AQUIND INTERCONNECTOR

Applicant's Response to Local Impact Reports

Document Ref: 7.7.13 PINS Ref.: EN020022

7. COMMENTS ON WINCHESTER CITY COUNCIL LOCAL IMPACT REPORT

Aquid Countryside Option

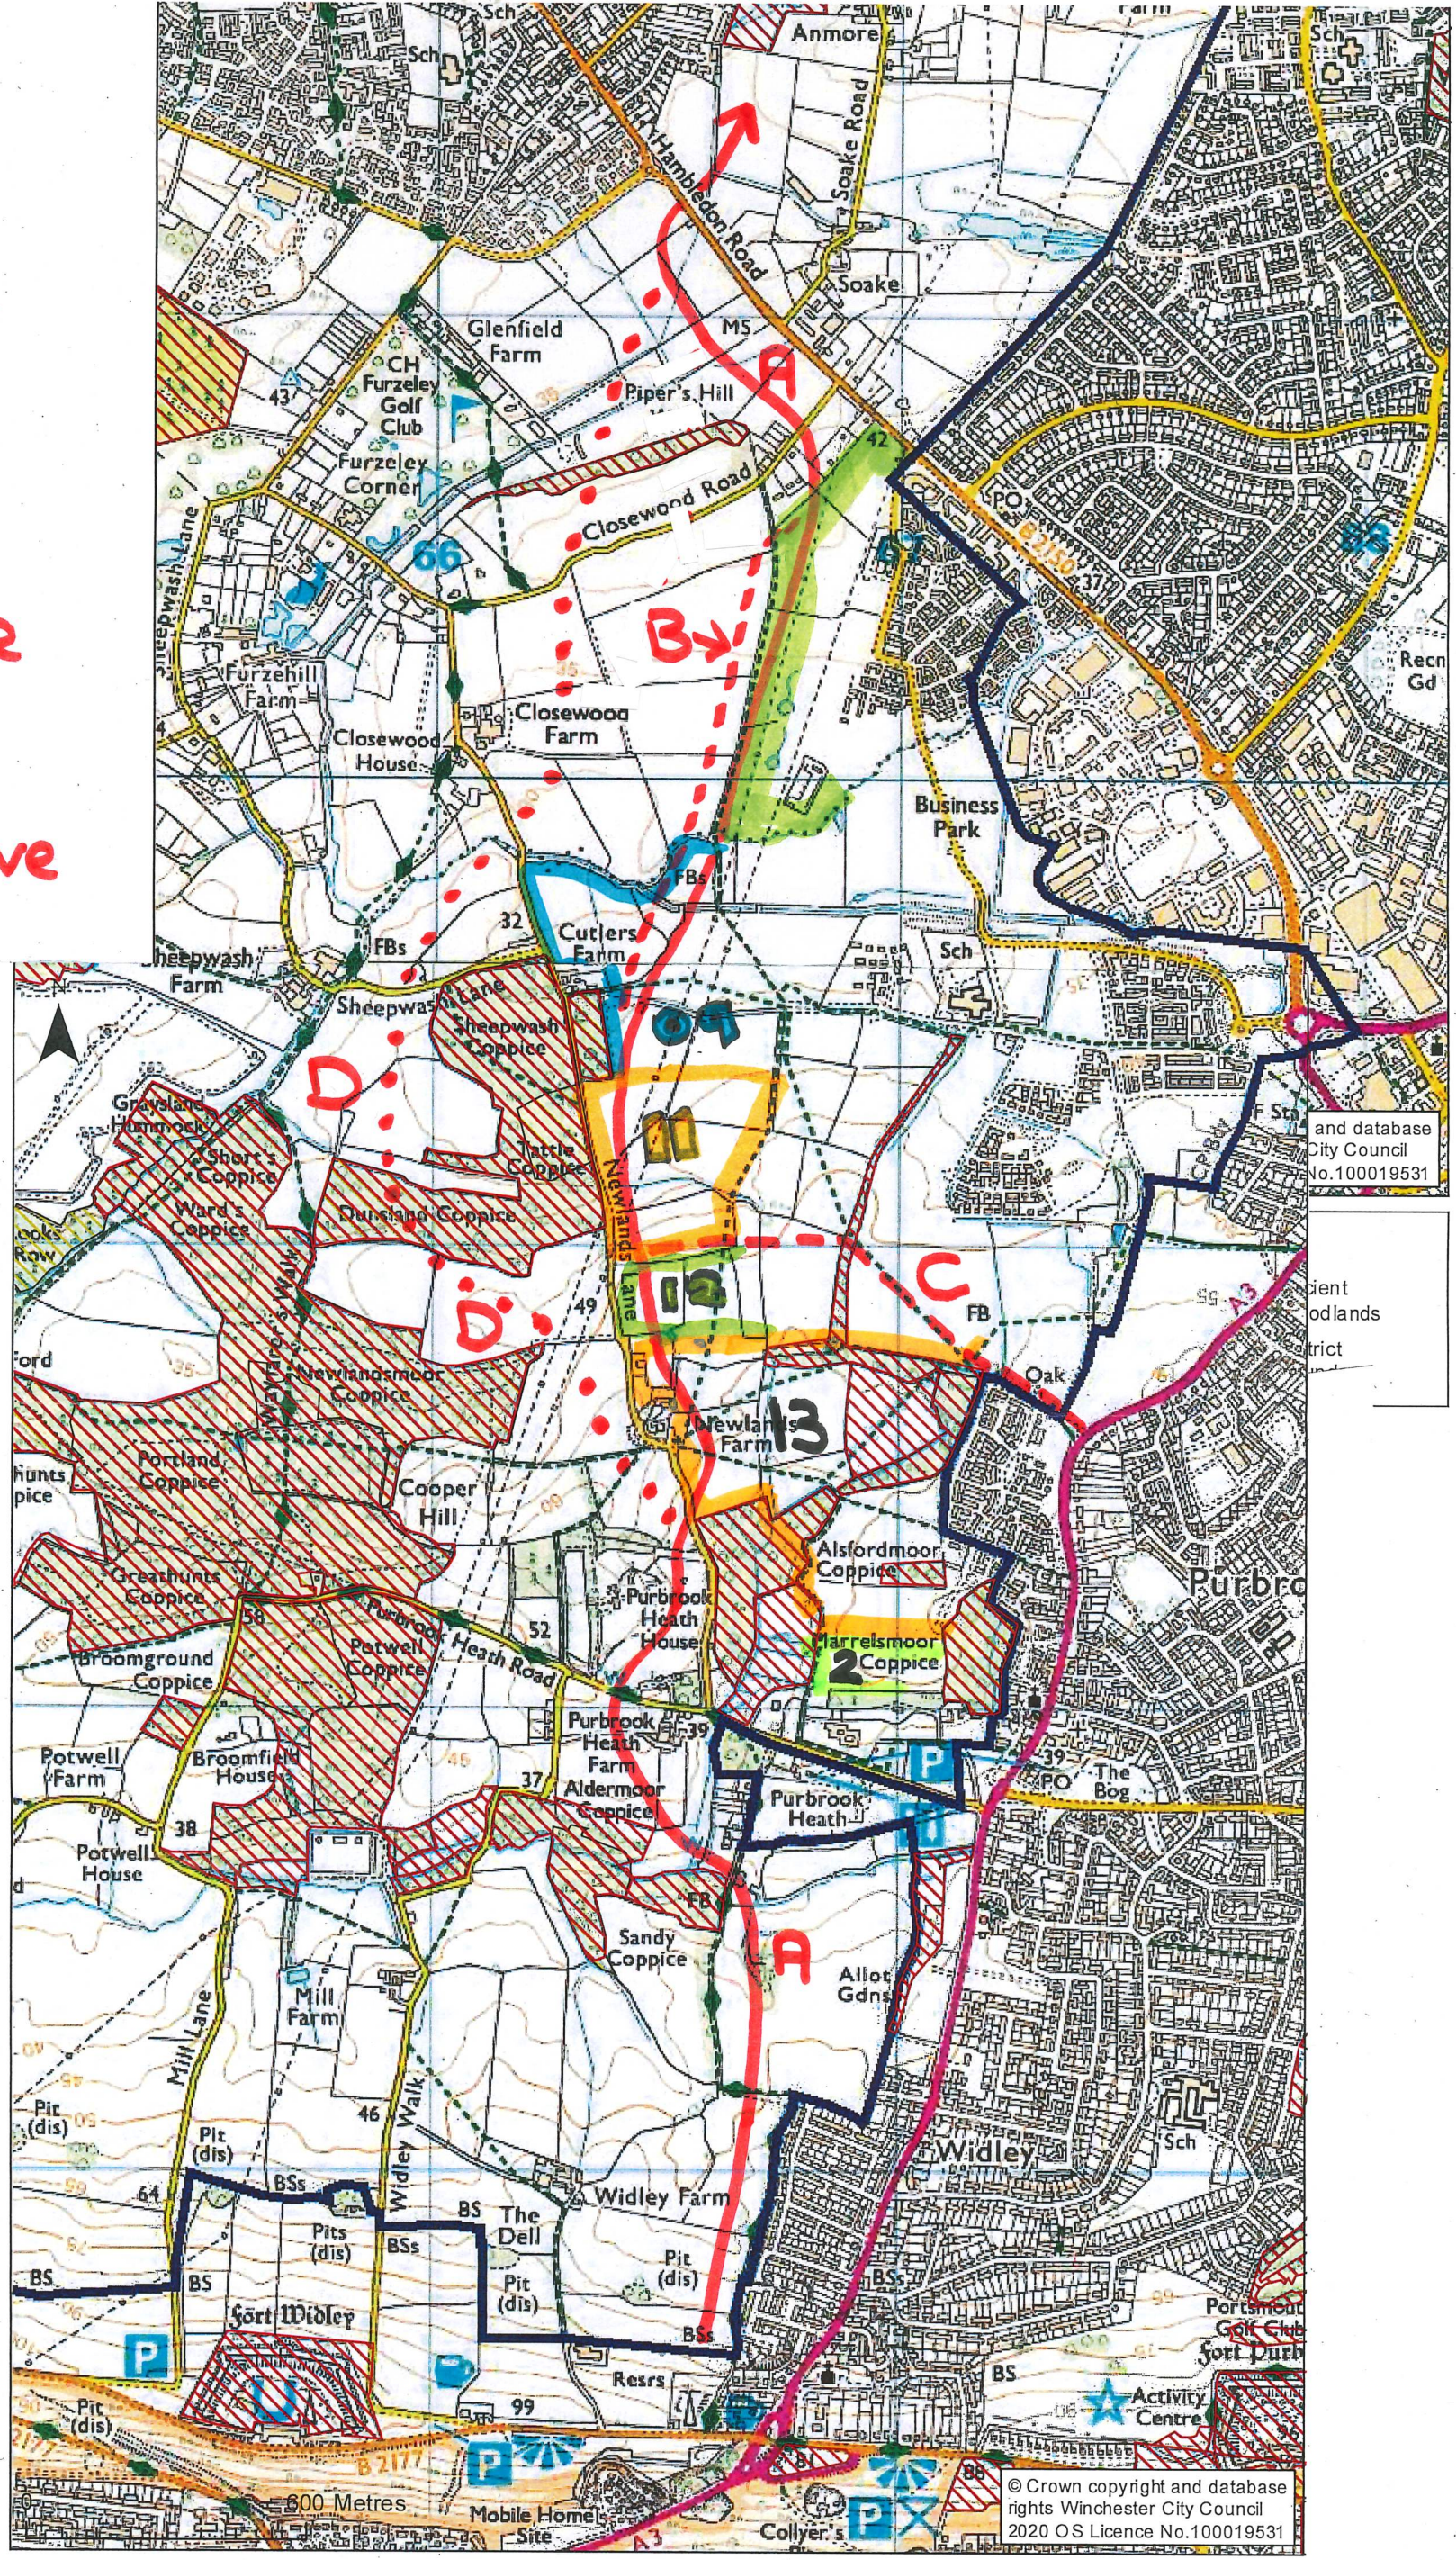
4.6.4.5	The study has considered two routes which are annotated on the attached plan as route A and route D. Route A avoids any SINC or ancient woodland and runs parallel to the over head pylon line. Where it runs through the West Waterlooville Development Area (WWDA) it would utilise what is intended to be open space. Route B is a slight deviation, avoiding the WWDA and move further away from the overhead route. By contrast route D avoids the WWDA completely. However, it would need to negotiate two designated woodlands. This could be achieved by horizontal drilling. The second jump off point part way up the A3 is identified as route C on the plan. This route runs west and could join route A, or it could continue across the southern edge of the woodland and joint route D.	<p>Havant Borough Council ('HBC') and Winchester City Council ('WCC') jointly requested the consideration of alternative options for the Onshore Cable Route (known as the 'Countryside Route'), which the Applicant had already considered. Further information regarding the identified potential impacts in relation to the Countryside Route and an indication of the main reasons for selecting the route chosen, including a comparison of the environmental effects between the two is set out in Section 8 of Supplementary Alternatives Chapter (REP1-152).</p> <p>Route D as illustrated in Appendix L of the WCC LIR is a new alternative being presented and as such has not been assessed by the Applicant and included in the supplementary alternatives chapter (REP1-152) or considered by the Applicant.</p> <p>The similarities of this route to the Countryside Route are noted, as is the effort to engineer an alternative which is less impactful than those previously put forward. Nonetheless, taking into account the main reasons which led to the selection of the highway route, being the desire to avoid construction impacts on ecological receptors (which remain in the vicinity and would likely be affected) and the sterilisation of land, and also to avoid the need to compulsorily acquire any land in this location, it is not considered the suggestions now advanced would alter the choice of the selection of the route selected for the Proposed Development.</p>
